Your Ref: 10_0204 MOD 2

Our Ref: S10/0036

14 March 2014

Modification Request – Catherine Hill Bay and Gwandalan residential subdivision

Image 1: Location of section of road 23 proposed to be deleted.

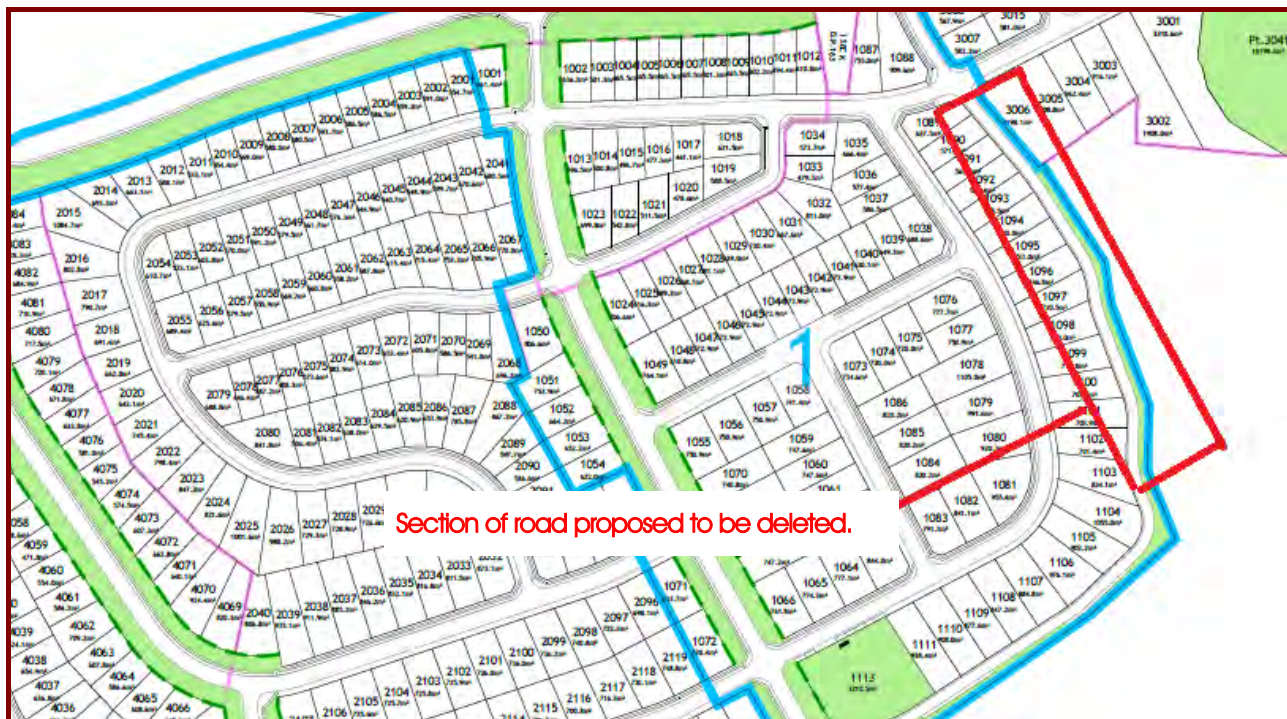
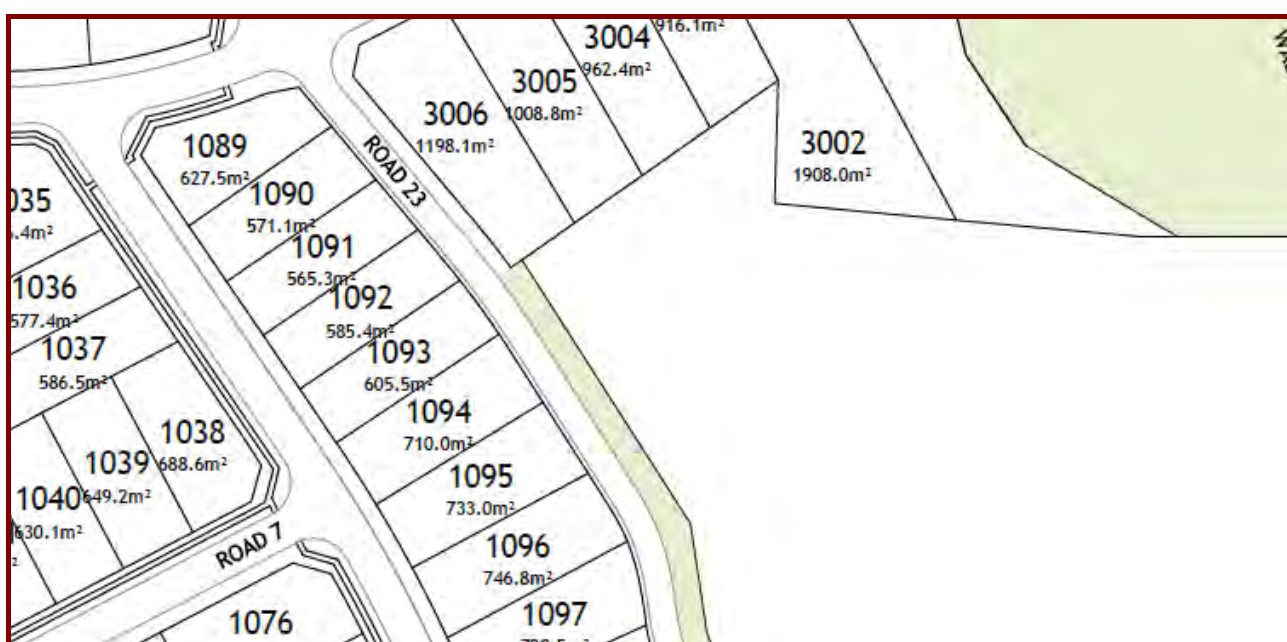
The Rural Fire Service acknowledges the engineering difficulties in constructing the perimeter road, as detailed in the submission by ADW Johnson. However, the Rural Fire Service does not accept this as justification for the deletion of this section of road (current road no. 23). Therefore, it is considered one of the following two alternatives could be pursued.

1. The subdivision layout is amended so that a perimeter road is still provided. Given the engineering difficulties the road would be further to the west from its current location, allowing the necessary engineering works to take place within the site.
2. Lot nos. 1093 to 1101 are deleted. Road no. 1 would then become the perimeter road in this location.

Plan of: STAGE 1
COMPARISON OF REVISED ROAD AND LOT LAYOUT

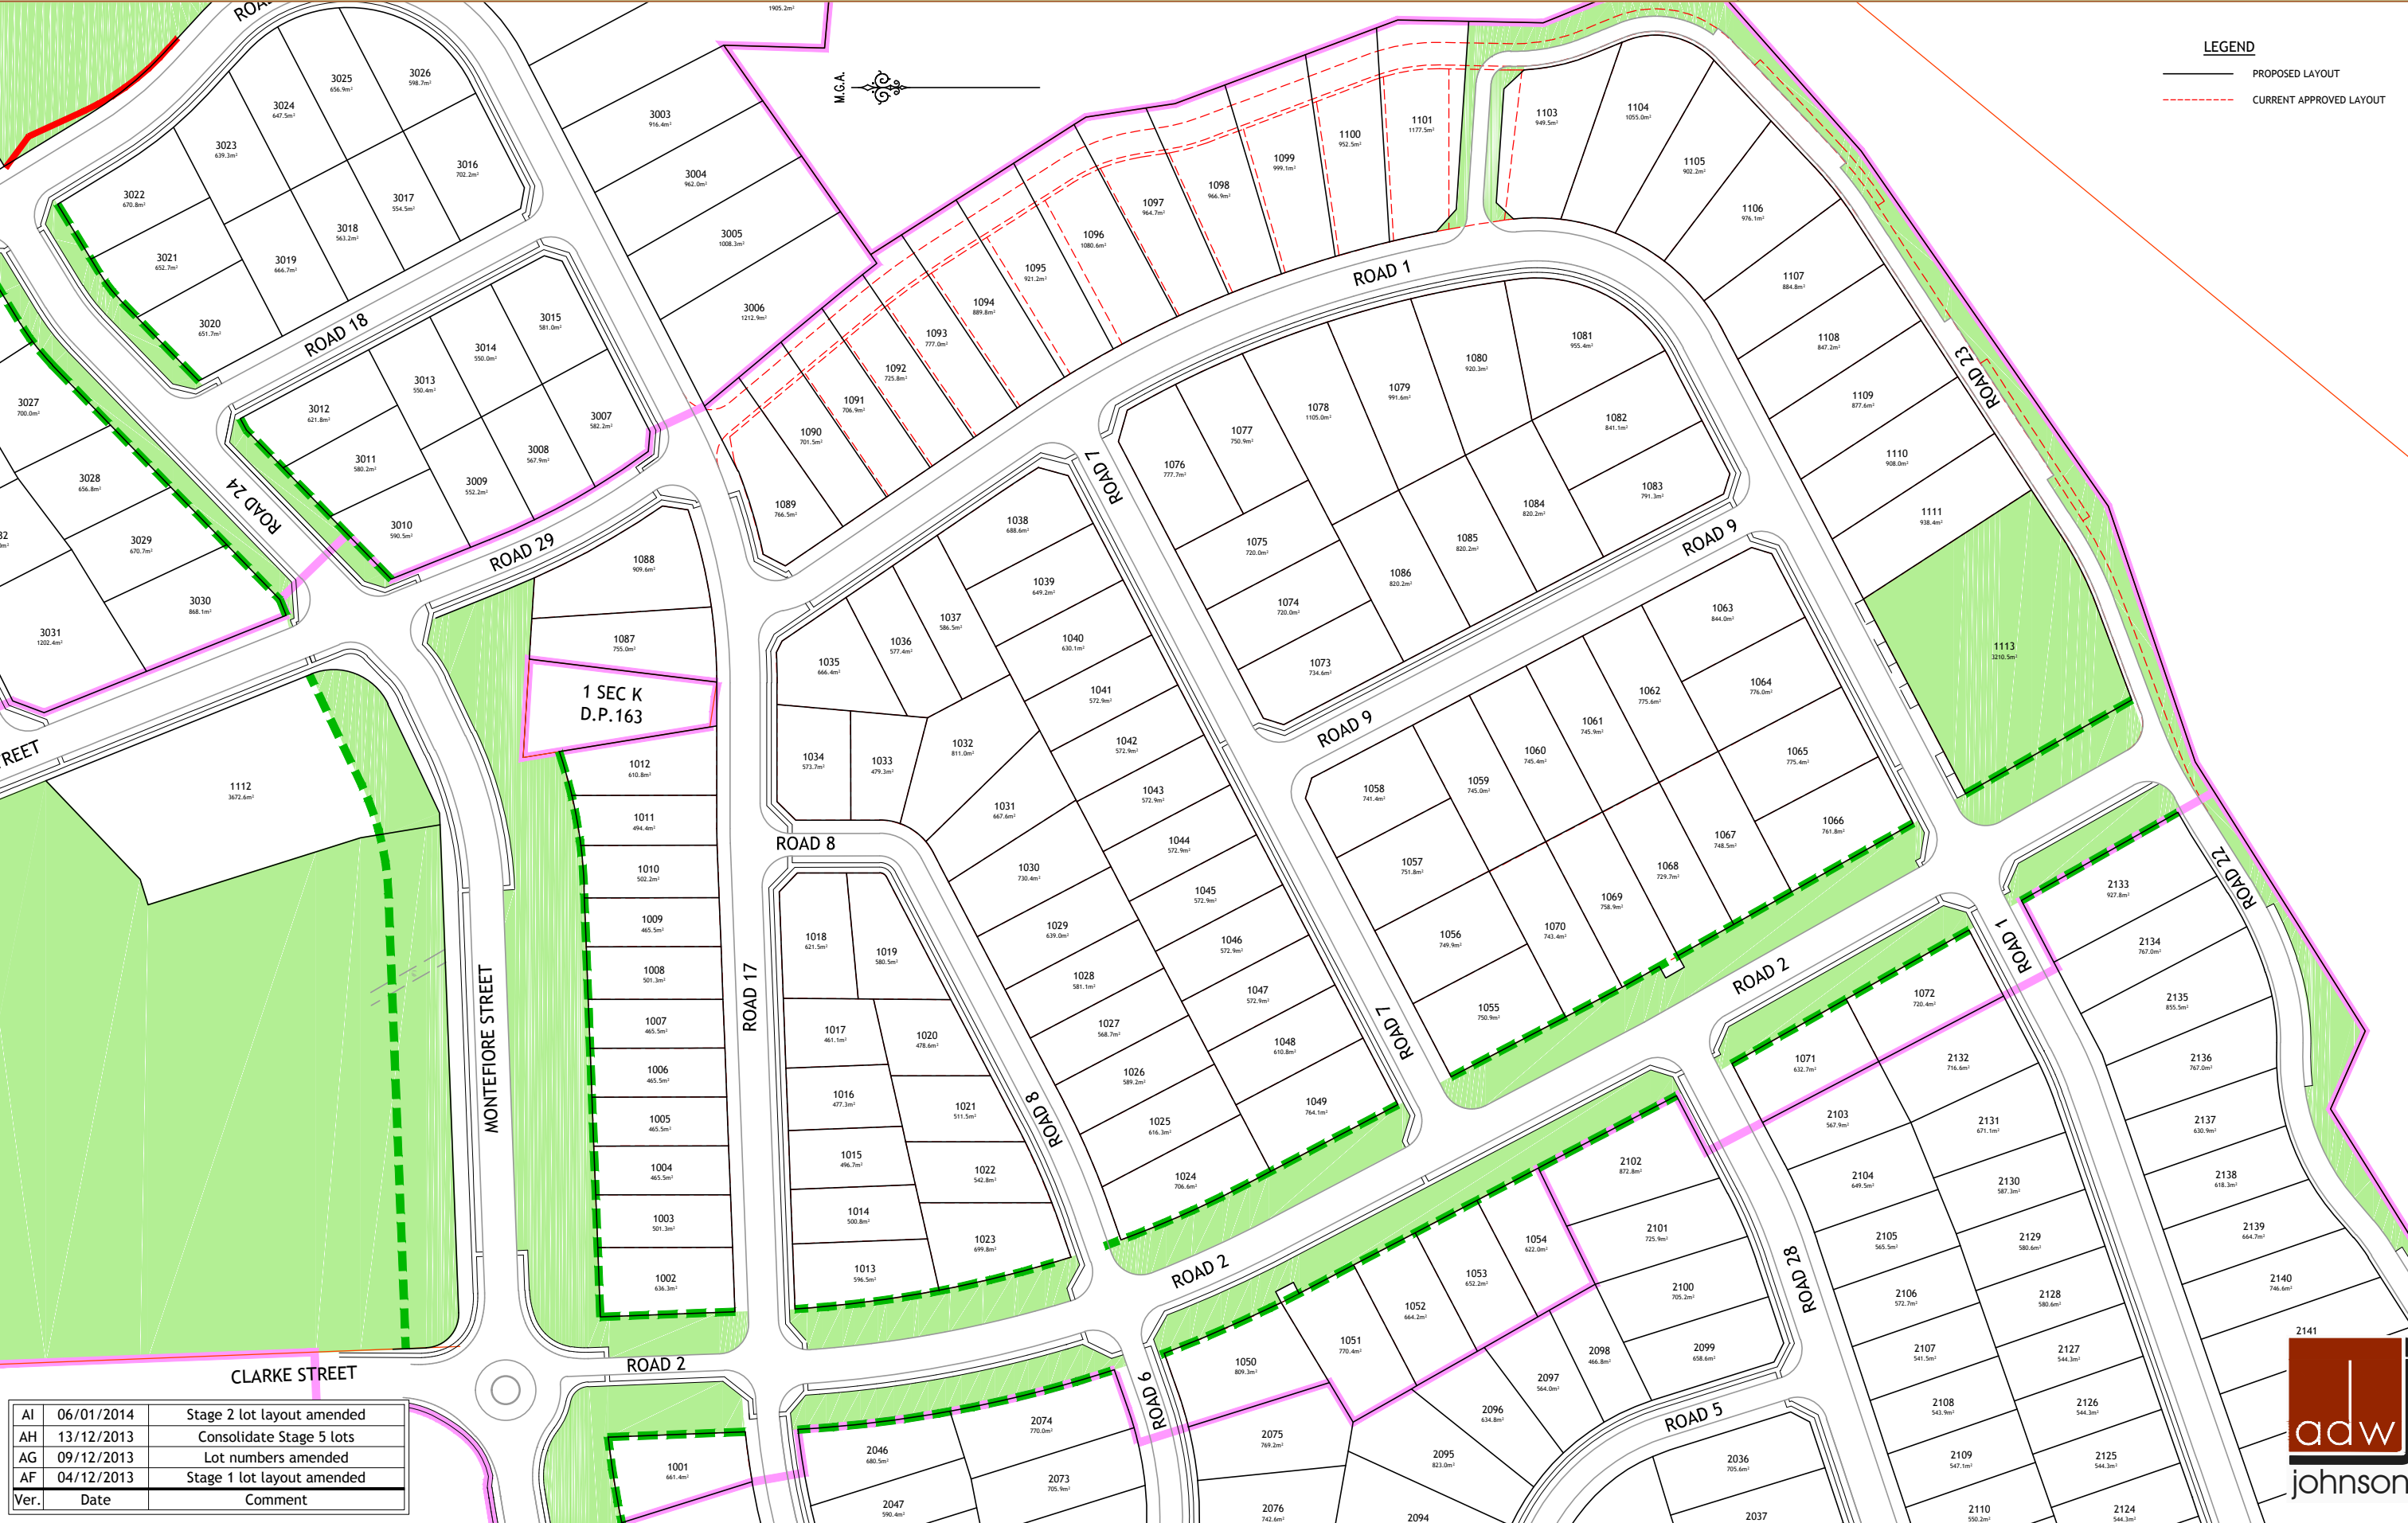
This requirement for an 8m two-way perimeter road is normally insisted on by the RFS. However, in this instance, the circumstances are slightly unusual in that these lots also have frontage to another road. The perimeter road is seen as a secondary access. Therefore, the narrower road width and one-way circulation may be accepted.
